Response to Planning Application

From: Arun District Council Greenspace

Application ref: Y/106/20/PL

Description: Construction of 3 (4) dwellings as temporary sales area & sales office including access, parking and landscaping. This site is in CIL Zone 2 and is CIL Liable as dwellings & affects a Public Right of Way.

Development	
Location	Ford Lane
Drawing Title	Yapton
Drawing Number	Sales Arena Layout
Revision	D
Scale @ A2	VARIES
Drawn By	DB
Date Started	March 2020
Checked by	
Date

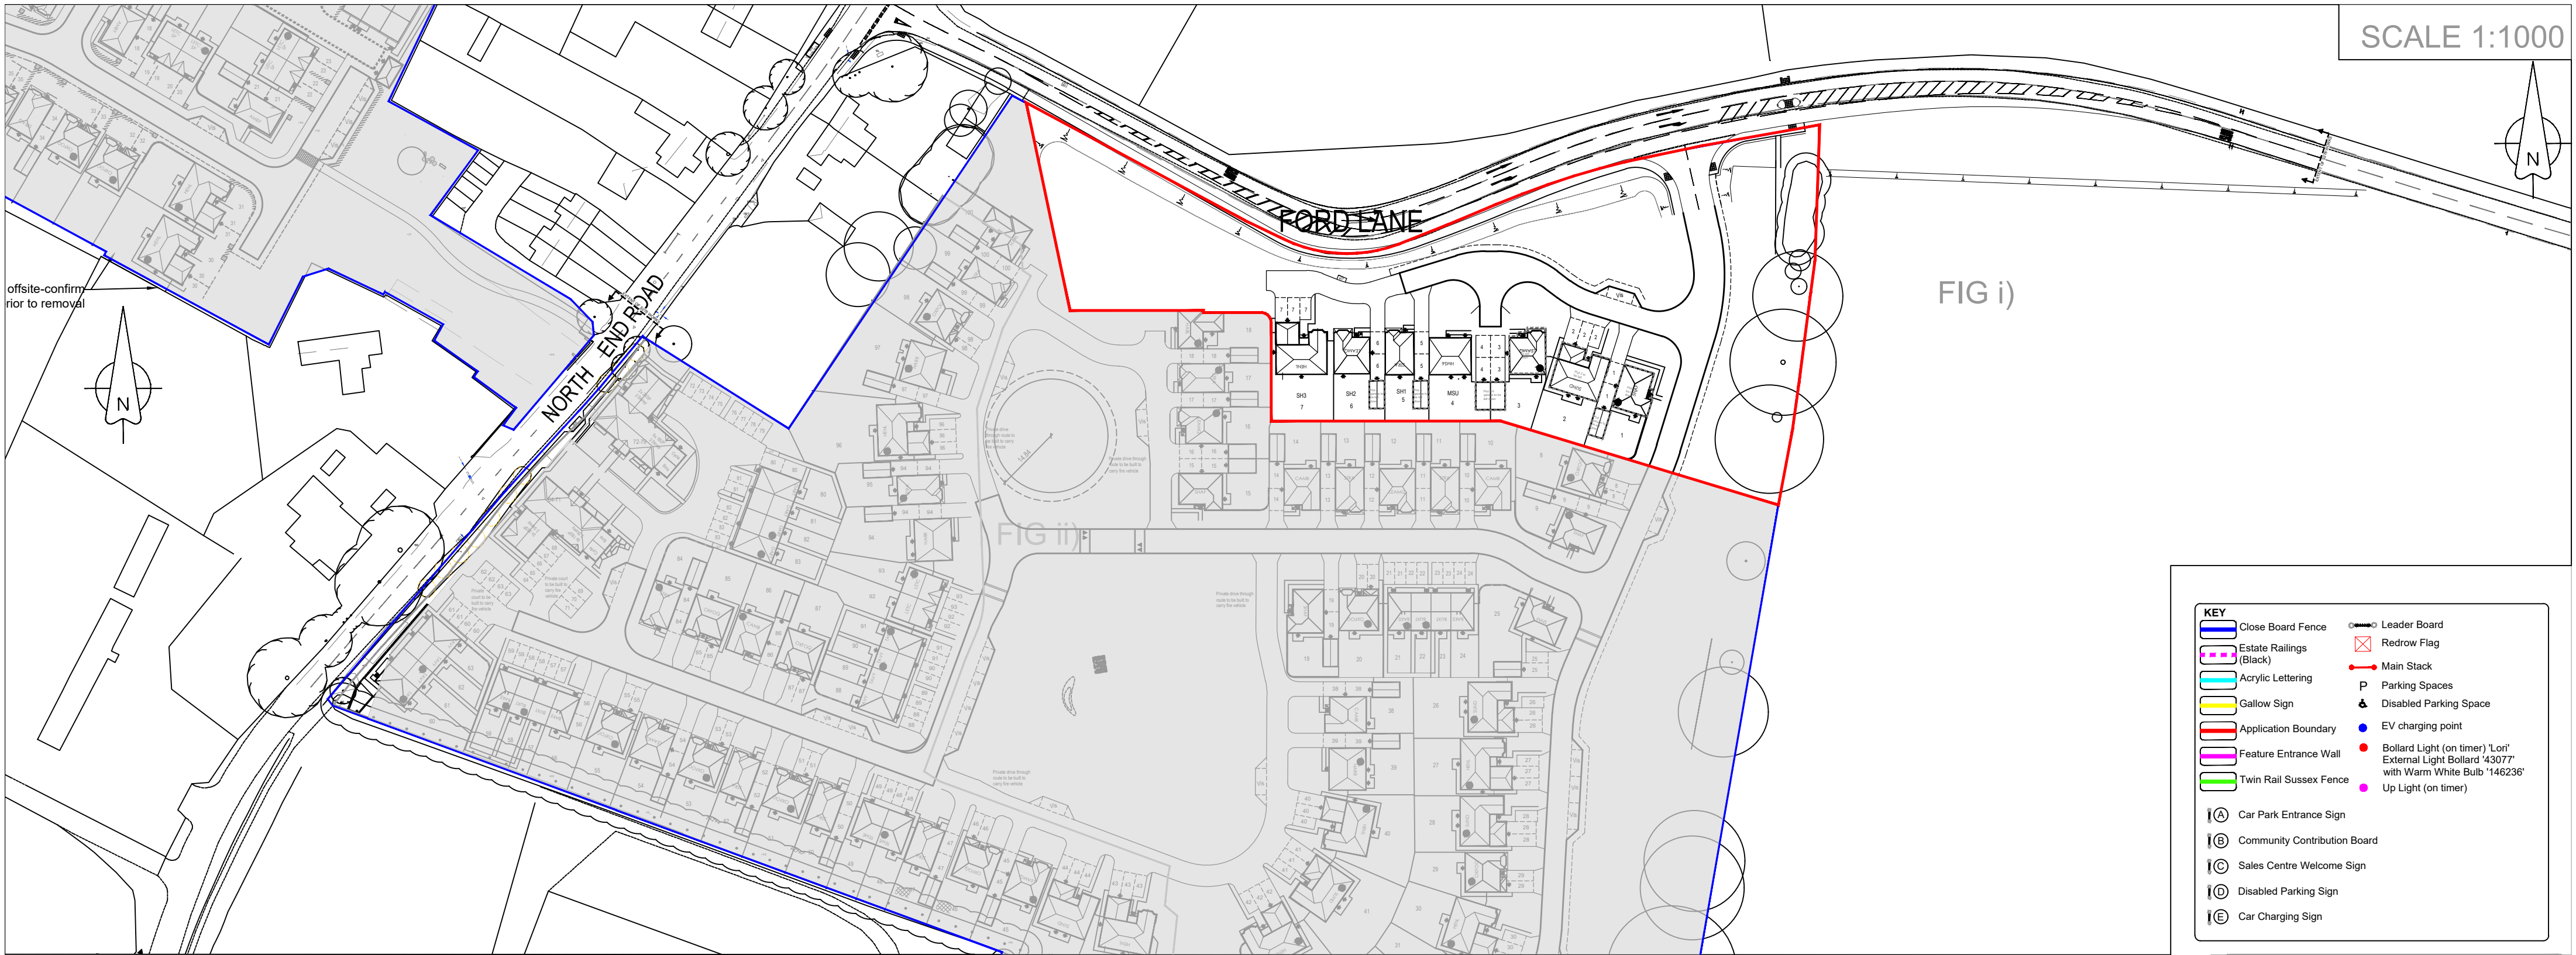
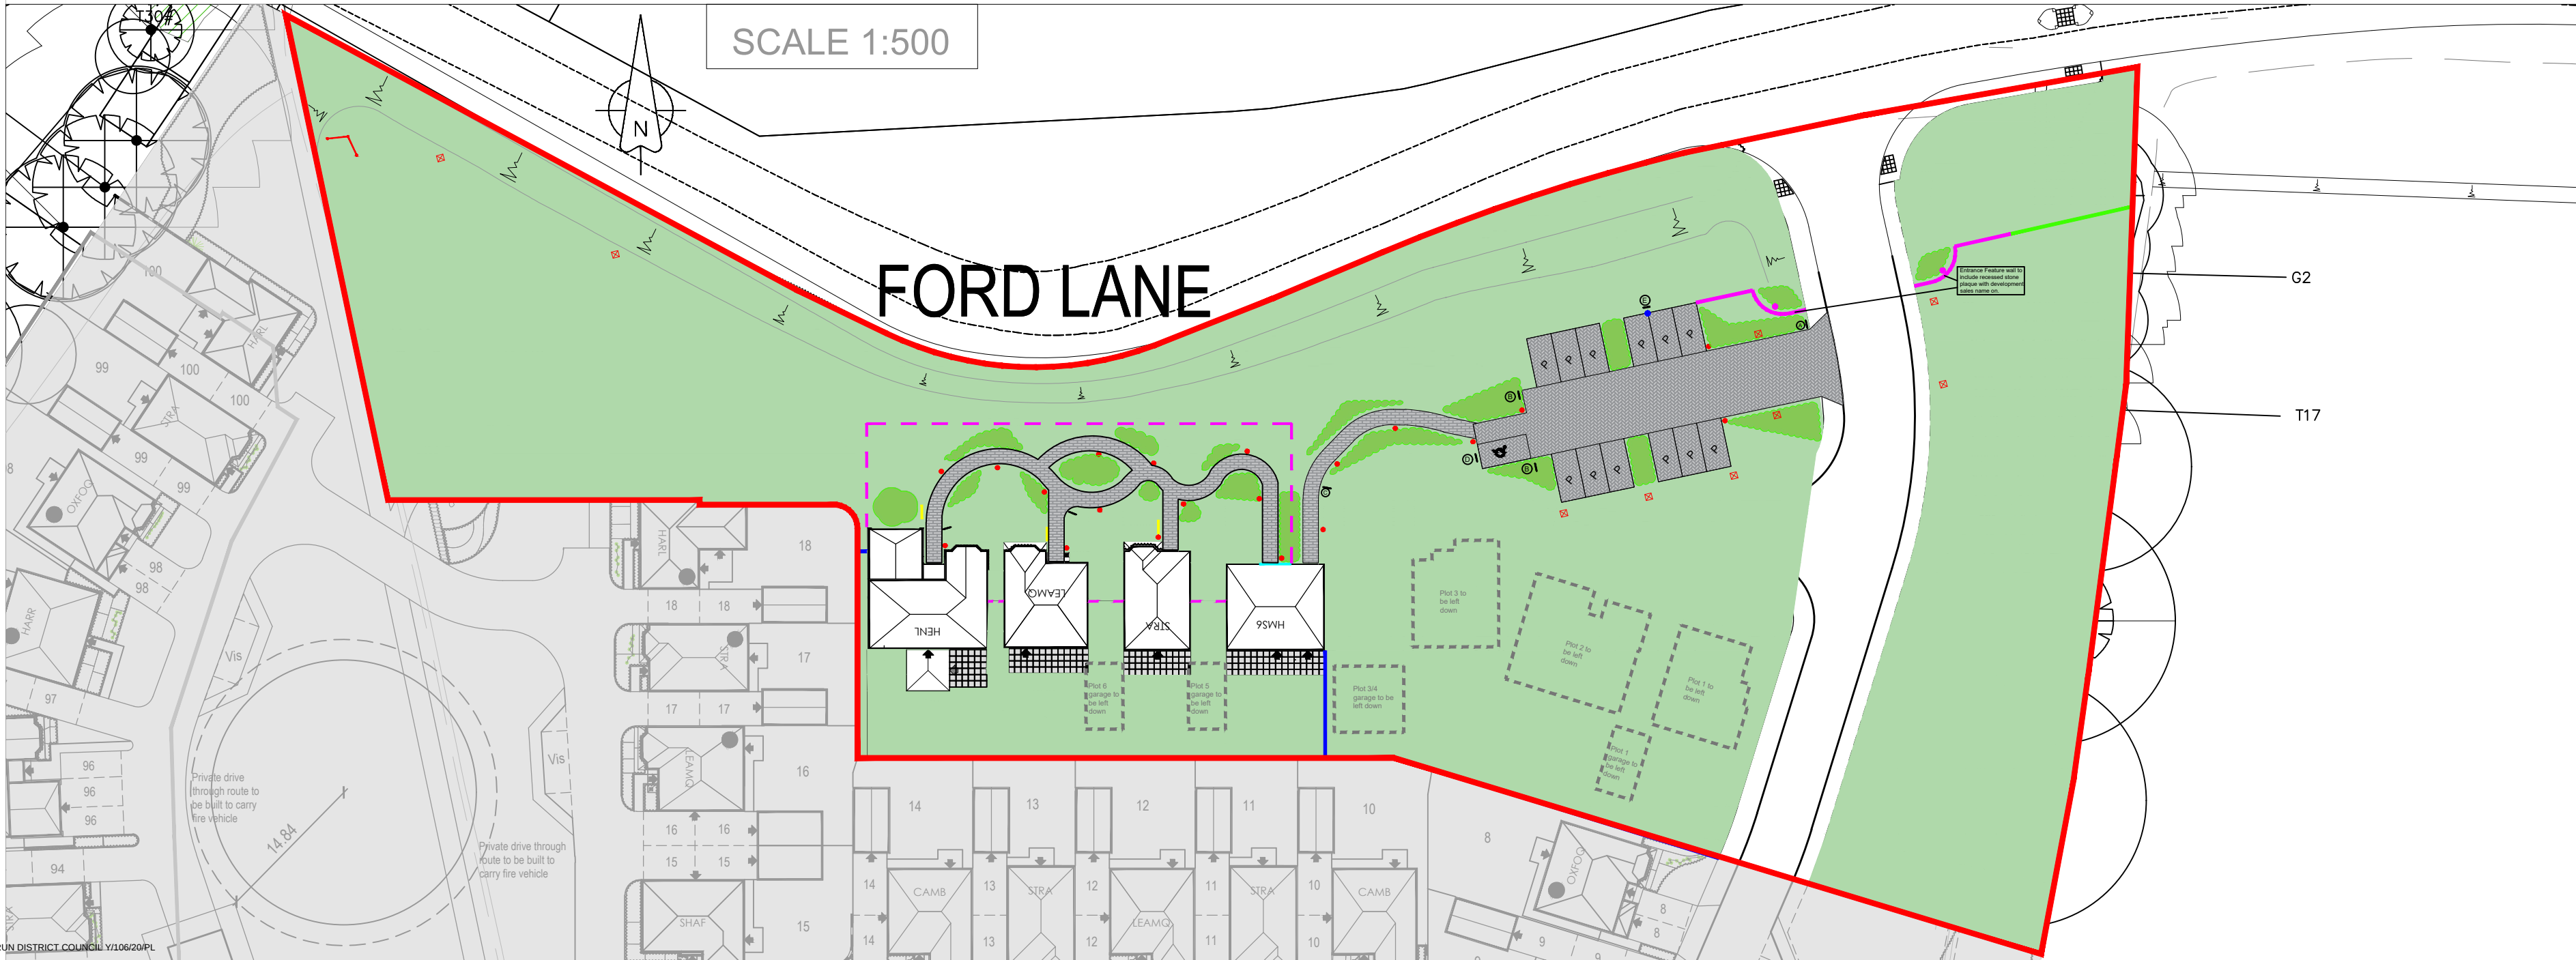
The proposals within this application are for the provision of show home and marketing suite facilities. Whilst the footprint of the 4no units will remain the landscaping and associated carparking will be temporary arrangements and therefore liable to change as the site develops.

The landscaping associated to these units will need to conform to the agreed site landscape design when these are no longer sales arena functioning.

The detail submitted under Detailed Planting Plan 0301 Rev PL00 and Sales Arena Coloured Masterplan D2831-FAB-00-GL-DR-L-0100 Rev PL00 has proposed a sales arena planting scheme which would be fitting for location and function, but as of a temporary nature is largely ornamental and liable to seasonal change.

The potential impact of the proposals will be temporary and generally viewed as not a long term provision due to the ornamental and seasonal nature of the proposals.

Further landscape provision will be required in line with approved landscape provision post sales arena usage. The planting will need to be in keeping with the street scene and the associated development.
